Community Observation on Carrow Wind Farm Noise Monitoring Positions

This community observation relates to the proposed Carrow Wind Farm noise assessment methodology and, specifically, the positioning and representativeness of the background noise monitoring stations identified in the EIA Chapter 12 – Noise and Vibration.

Figure 12-2 Indicative measurement locations (A, B, C, D, and E).

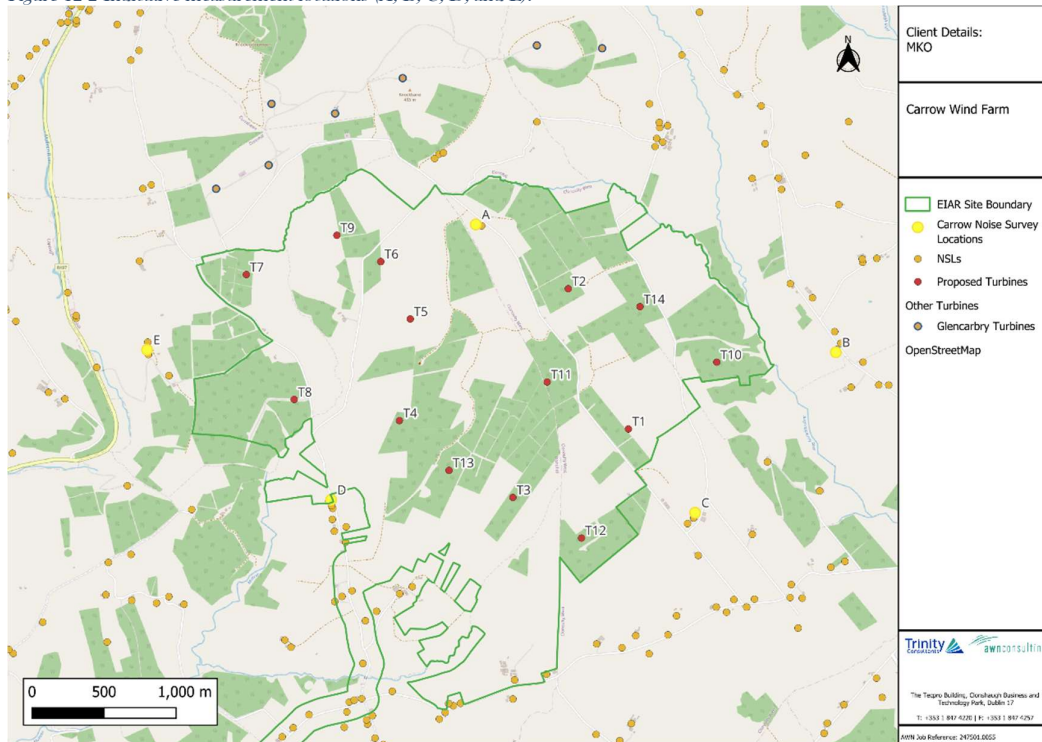
The mapped monitoring locations appear concentrated around certain sections of the development footprint while other potentially affected residential areas may have limited direct representation.

- Why these specific locations were selected;
 - Whether any proposed turbine sectors are underrepresented;
 - Whether locations with known quiet nighttime conditions were excluded;
 - Whether any homes closer to prevailing downwind directions should also have been monitored.
-

The mapped monitoring locations suggest that large areas of the development rely on representative assumptions rather than direct long-term receptor monitoring.
